3 June 2025

Department of Planning Housing and Infrastructure
Locked Bag 5022
Parramatta NSW 2124
Attention: Adele Murimba

Re SSD 81890707 10, 14 & 14a Stanhope Rd Killara

Figure 12: Shadow diagrams of the proposed development (Source: PBD Architects)

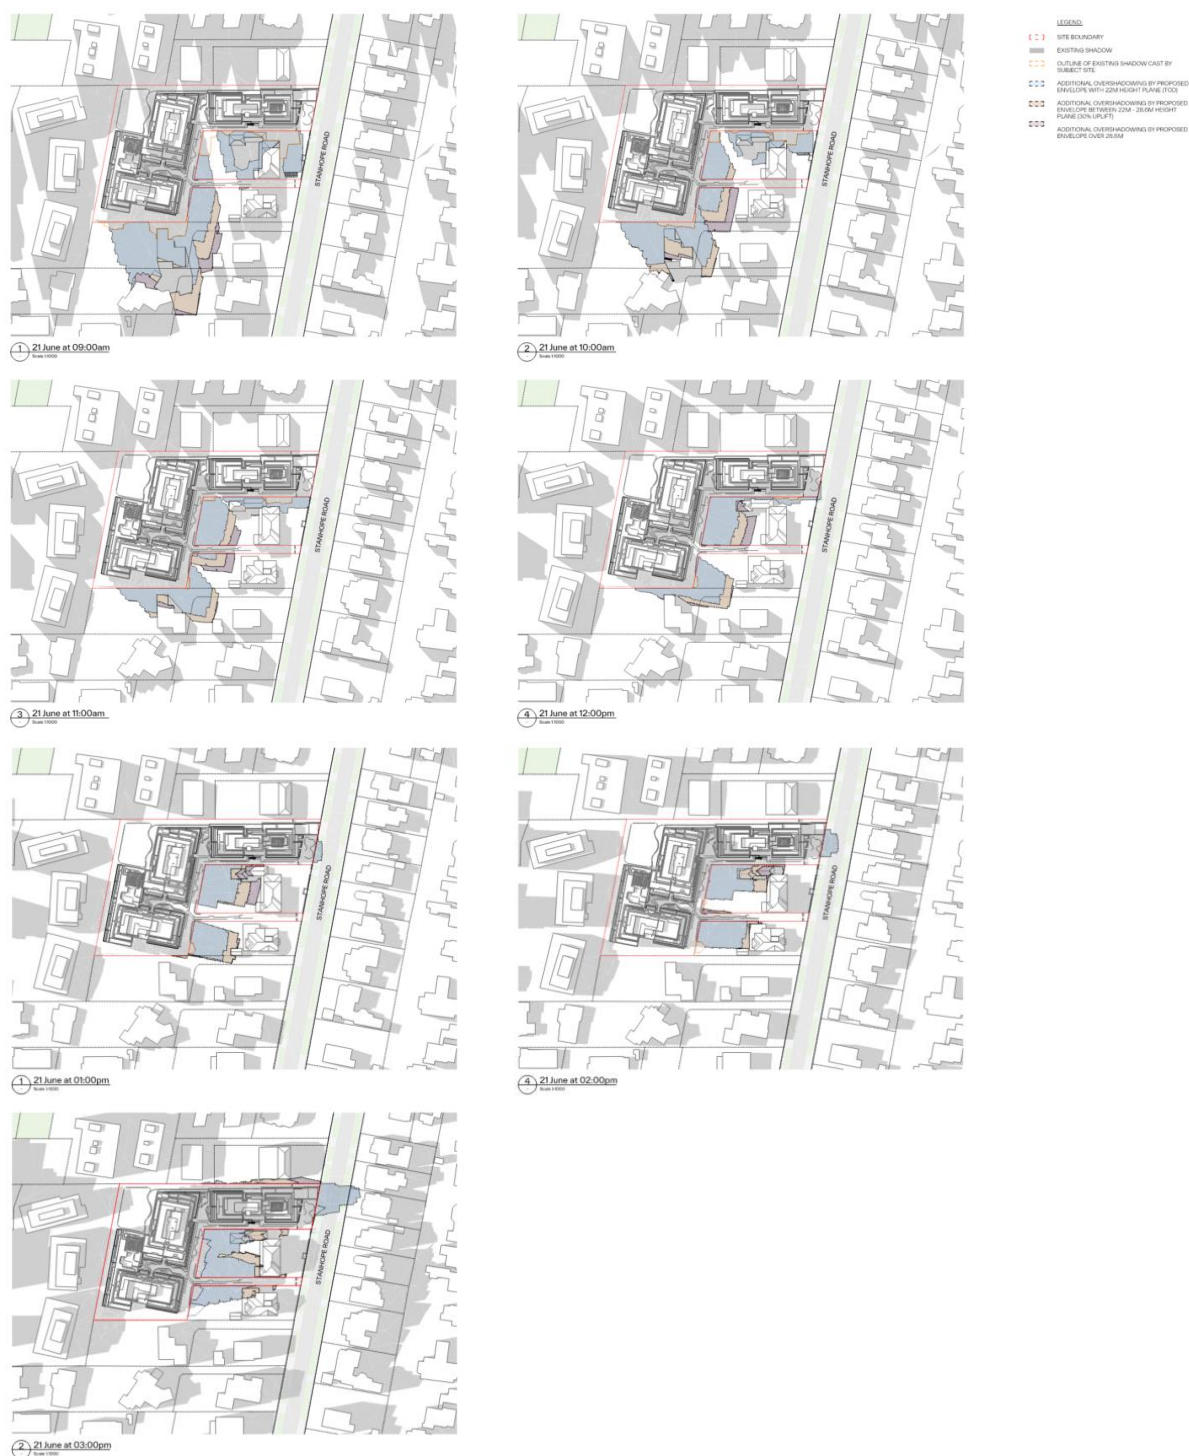
Shadow diagrams on page 62 of the EIS show the severity of shadowing on No 12, 8, 6A and 6 Stanhope Rd with shadowing impacts also reaching No 4, 4A and 17 Stanhope Rd. This is an unacceptable loss of environmental amenity.
